From: Daun Johnson
Sent: 23 November 2020 16:05
To: Planning Scanning
Subject: FW: PP-07769181. - The Garage, 70a Tarrant Street, Arundel, BN18 9DN

Please upload email to AB/118/20/PL

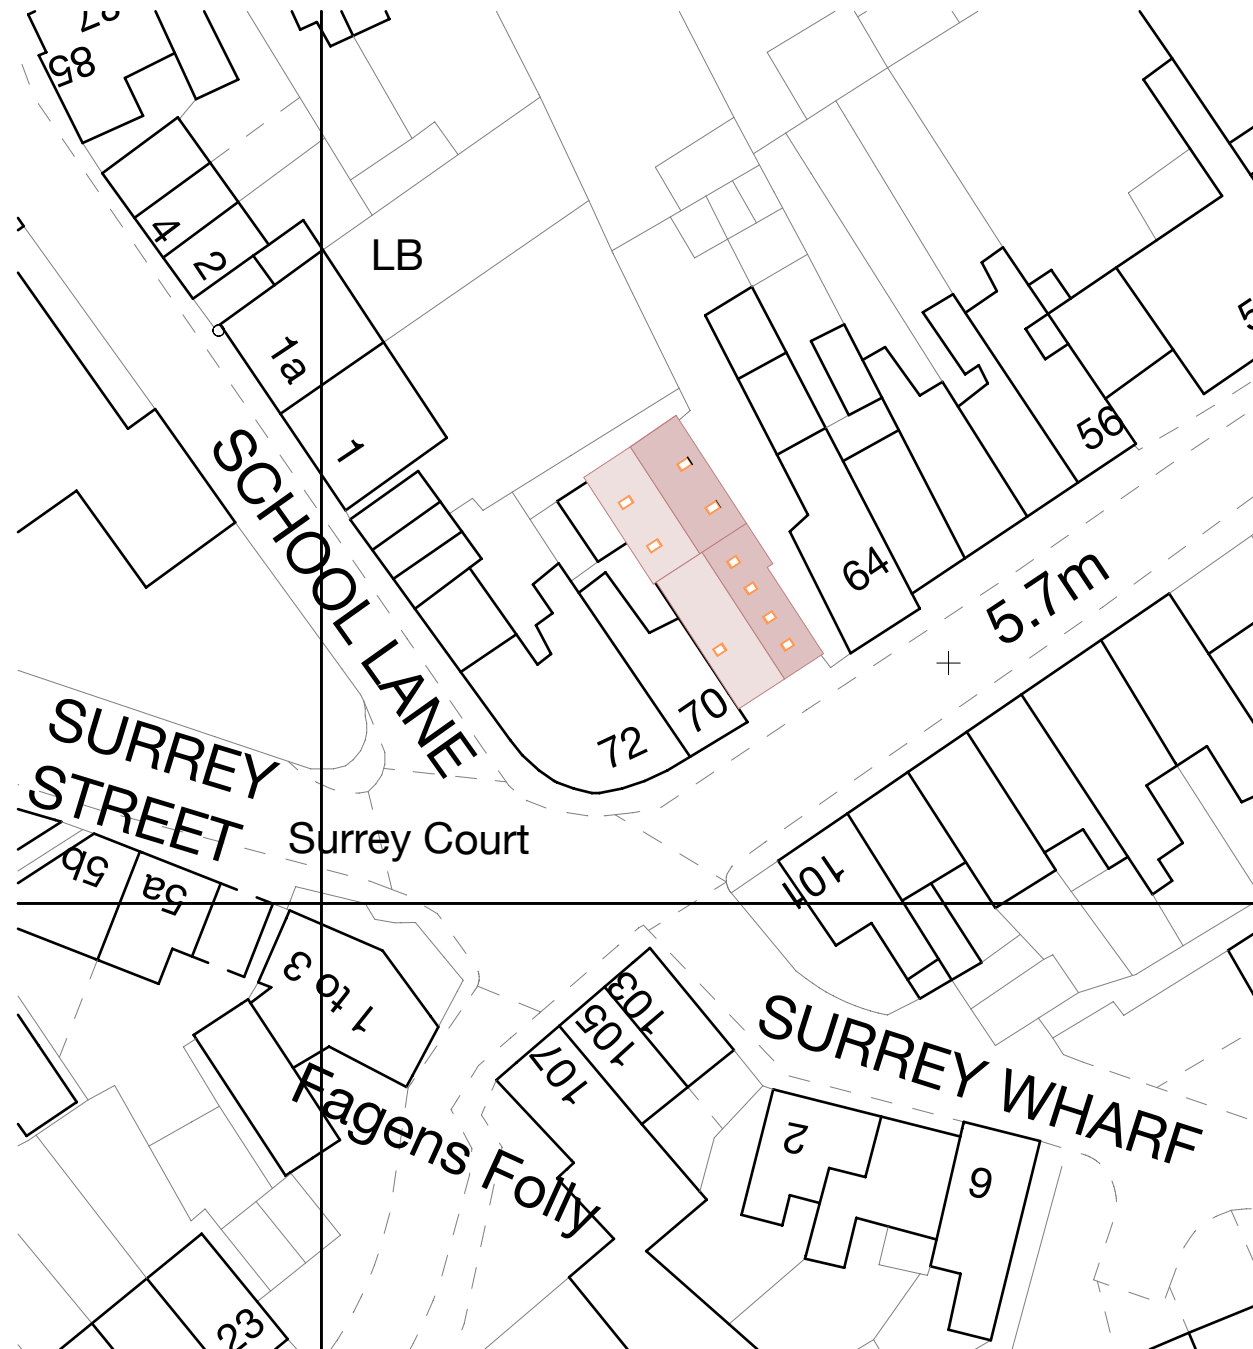
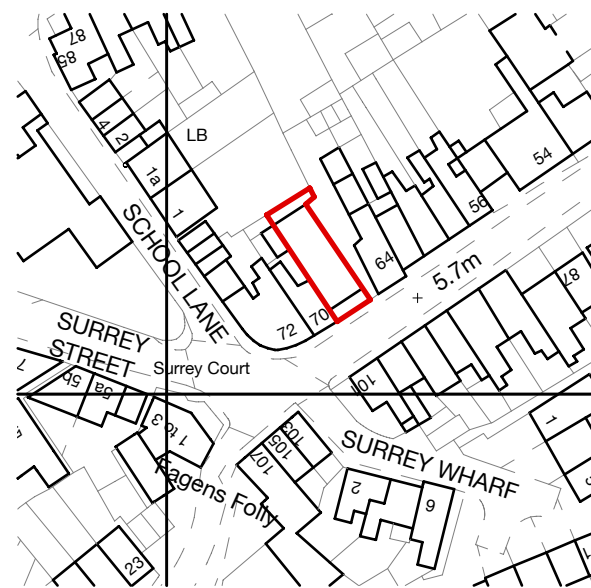
Also, the location plan needs a north point and I don't seem to have a Block plan.

I am still waiting on Certificate A to be re-dated, the location and block plan need a North Point, and a Biodiversity Survey due to the fact the site is in the Arun Valley IRZ Zone .

The Location and Block are on the same document 01A. Attached again for ease.
